<b>Preliminary Approval Conditions</b>	<b>Applicant Response</b>	<b>Staff Review</b>
<p>The project shall proceed in substantial conformance with the plans and application materials on file dated June 10, 2008. Updated drawings will be required for final platting with a currently licensed surveyor and updated property owner names.</p>	<p>Agreed</p>	
<p>The applicant is responsible for compliance with all applicable local, state and federal rules and regulations, and must obtain all appropriate permits and approvals.</p>	<p>Agreed</p>	
<p>All future development near critical areas shall be consistent with KCC Title 17A.</p>	<p>Agreed</p>	
<p>All current and future landowners must comply with International Fire Code.</p>	<p>Agreed</p>	
<p>All accesses and roads shall be 2006 IFC compliant. It is the responsibility of the applicant to contact the Kittitas County Assessor's and Treasurer's offices to confirm all taxes are current prior to final plat approval.</p>	<p>Agreed</p>

2 OF 3

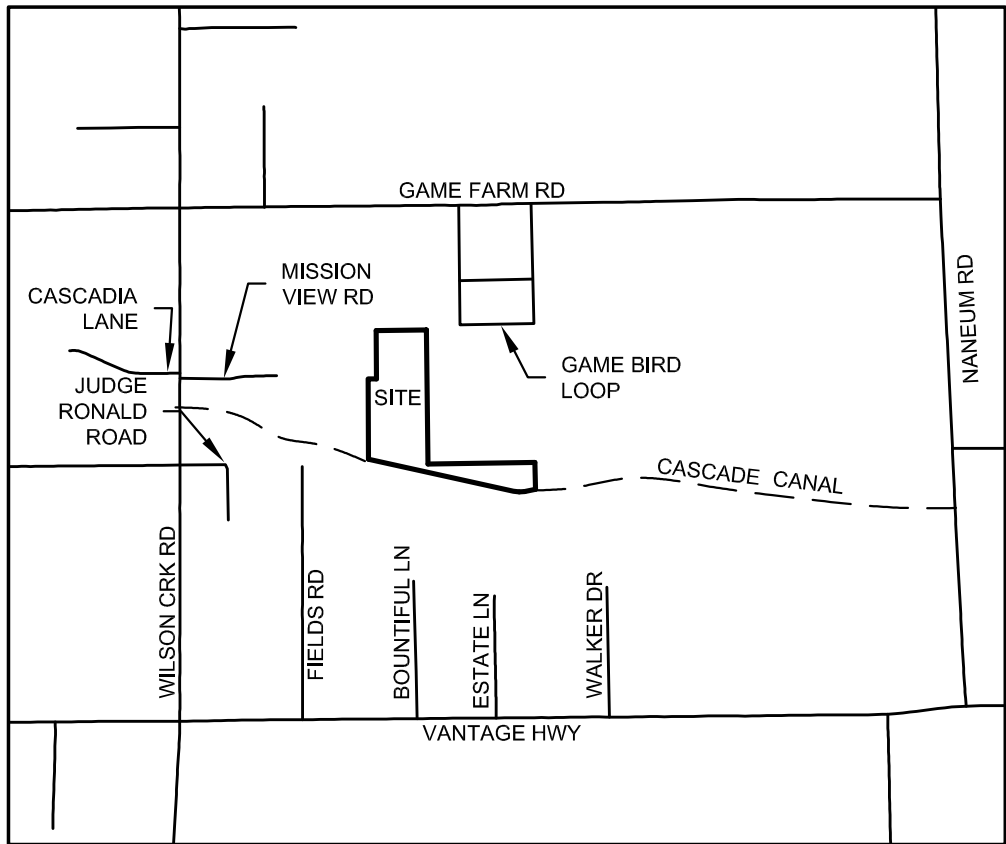
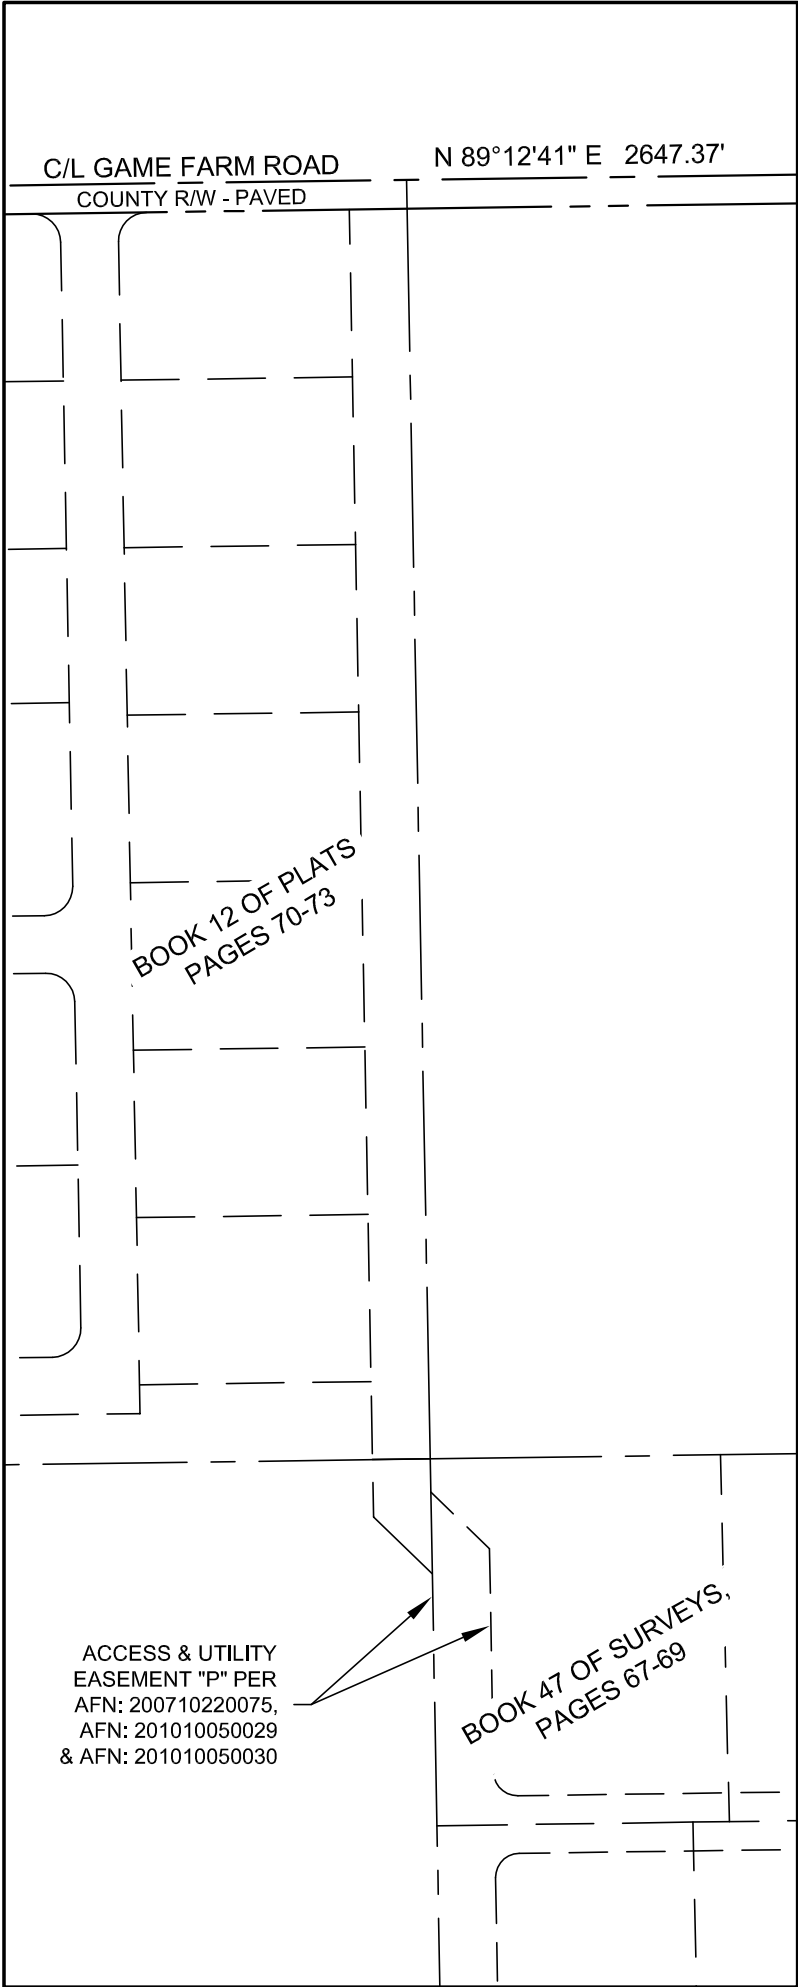
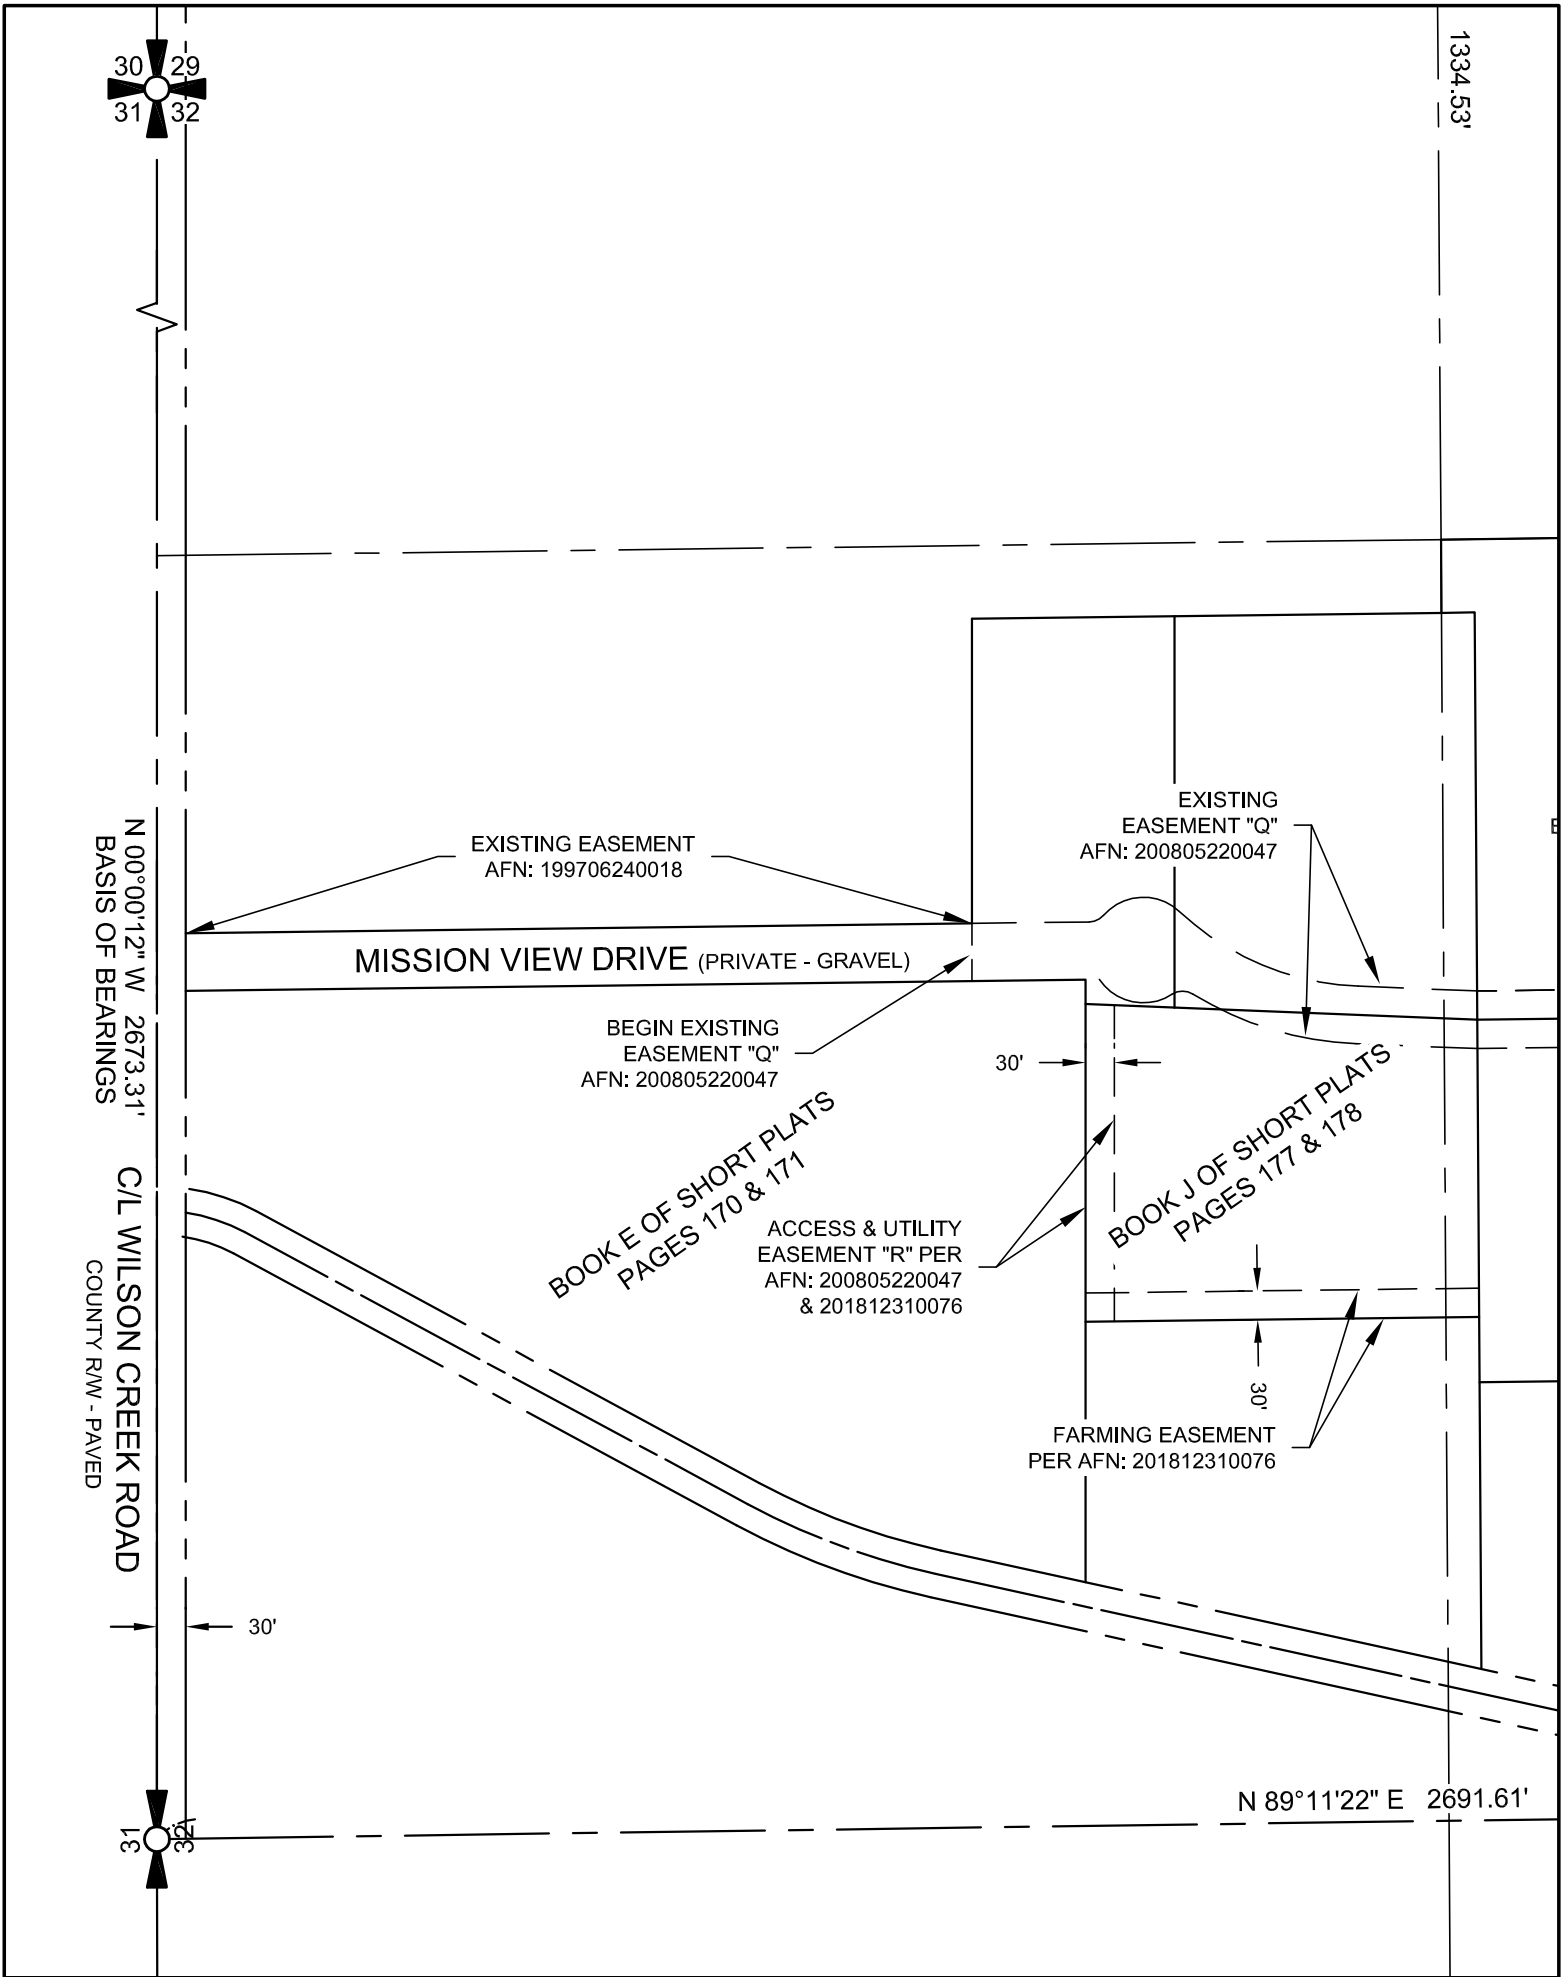
<p>The plat shall meet all the requirements of KCC Title 13: Water and Sewers prior to final plat approval. Applicant is to verify with Kittitas County Public Health for requirements.</p>	<p>Agreed</p>	
<p>The following shall be updated on the final plat:  32.1 For the 60' access easement, please show public access (including recording numbers) of easements to a public right of way.  32.2 The plat will need to be stamped and signed by a surveyor actively licensed in the State of Washington.  32.3 Adjacent property owners list will need to be updated to current property owners.  32.4 The vicinity will need to be updated on the face of the plat.  32.5 The access easement over lots A through F will need to have radii dimensions shown.  32.6 All dimensions shall not be obscured by crossing linework.  32.7 The contact information for the survey firm will need to be updated.  32.8 It is assumed that the corners shown as found, in the preliminary plat, but do not have dimensions shown to tie them are NOT part of any survey control network utilized to determine the boundaries as shown. Please clarify this for final platting.</p>	<p>Agreed</p>
